TECHNICAL NOTE

from:	[REDACTED]	date:	16/2/2022
subject:	3/2020/0911. Shackletons Garden Centre Ltd Clitheroe Road Chatburn BB7 4JY, Proposed two-storey extension Including additional indoor and outdoor retail space and increased cafe area and play area.	file ref:	J1168-TN1

name: **access sections - existing and proposed**

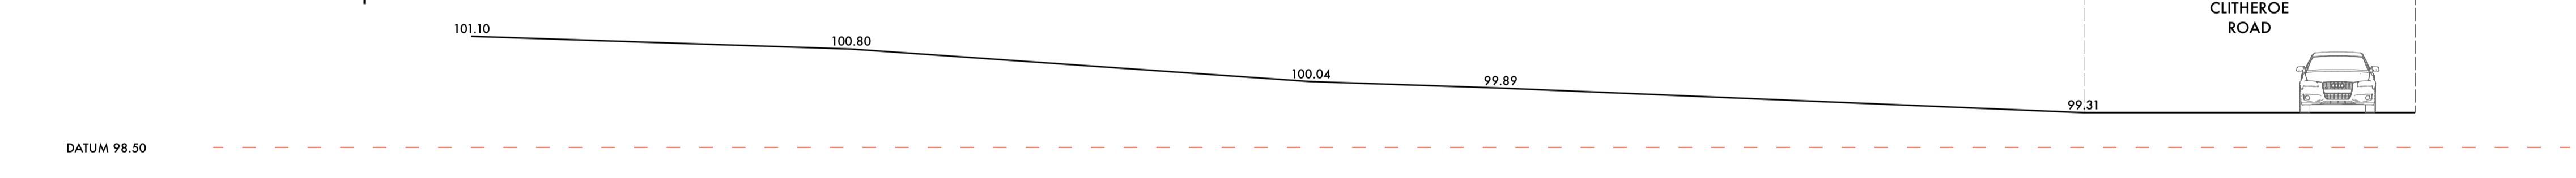
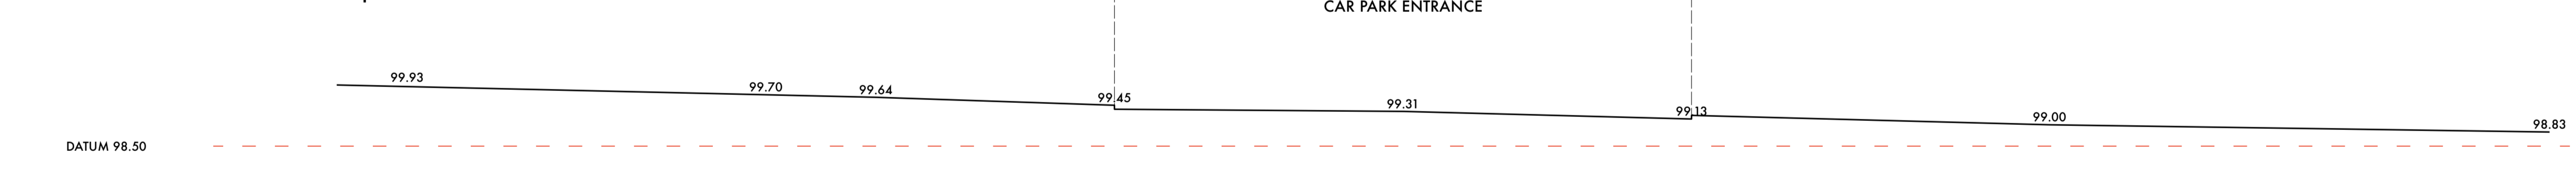
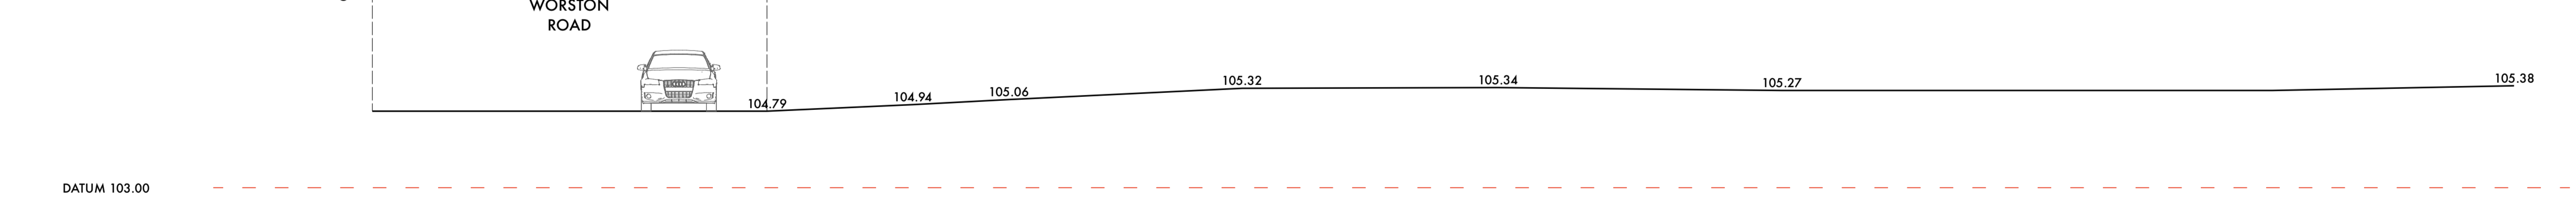
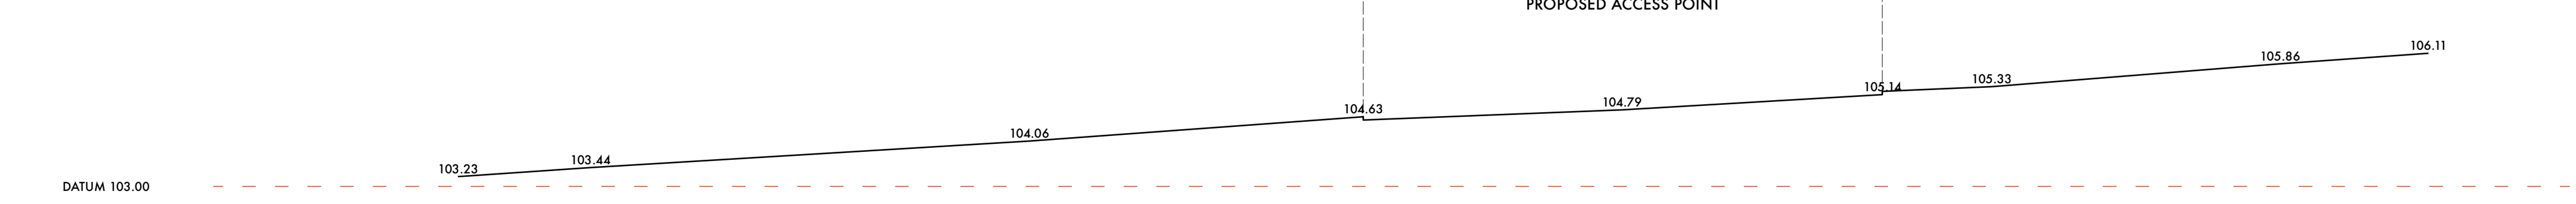
The LHA have reviewed the revised site plan provided by Stanton Andrews and understands that the width of the proposed access will be approximately 10m wide adjacent to the public highway. This will be reduced to an internal carriageway width of approximately 6.2m, a distance of 18m from the public highway.

The LHA also have concerns associated with the site entrance/exit having 3 lanes as shown on the drawing. This is because the width of the carriageway which is approximately 6.2m wide, is extremely narrow to incorporate 3 lanes. Therefore, the LHA are concerned that due to the carriageway being narrow that conflicts could occur between vehicles manoeuvring into the correct lane.

Not only this but the LHA are concerned that vehicular visibility for vehicles using the left lane will be skewed when vehicles are using the right lane when exiting the site. This is because the vehicle in the right lane will be blocking the view which could cause conflicts to occur should vehicles in the left lane guess when the road is clear. This would be to the detriment of highway safety.

Therefore, the LHA advise that only two lanes are used at the site entrance/exist. This should be shown along with the relocation of the site access on a revised drawing

While the LHA have reviewed the drawing and the access arrangements along with the visibility splays comply with the LHAs guidance, the LHA are concerned about large delivery vehicles using the access. This is because as shown on the swept path analysis drawing on the revised plan, the delivery vehicle exiting the site and turning right onto Worston Road, overlaps the grass verge and then the footway as it exits the site.

The drawing also shows its extremely narrow for delivery vehicles to enter the site, with the swept path being extremely close to the footway. Therefore, the LHA require the access and the carriageway into the site to be widened which should be shown on a revised drawing. A revised swept path analysis drawing should also be submitted.

The road width was designed to accommodate 2 out and 1 in for cars only to the car park with a width ranging from 6.2m to over 8m

That said the junction with the centre line and markings shown as below delivers the access in a simpler form with a 6m width.

The paths have been updated to show the turn can take place with no overlaps, it should be noted that the green lines indicate the edge of the vehicle body and the redlines the track of the wheels.

That path to the left on exit extends around 10m, there are no paths south of the site as such any users would be limited in numbers.
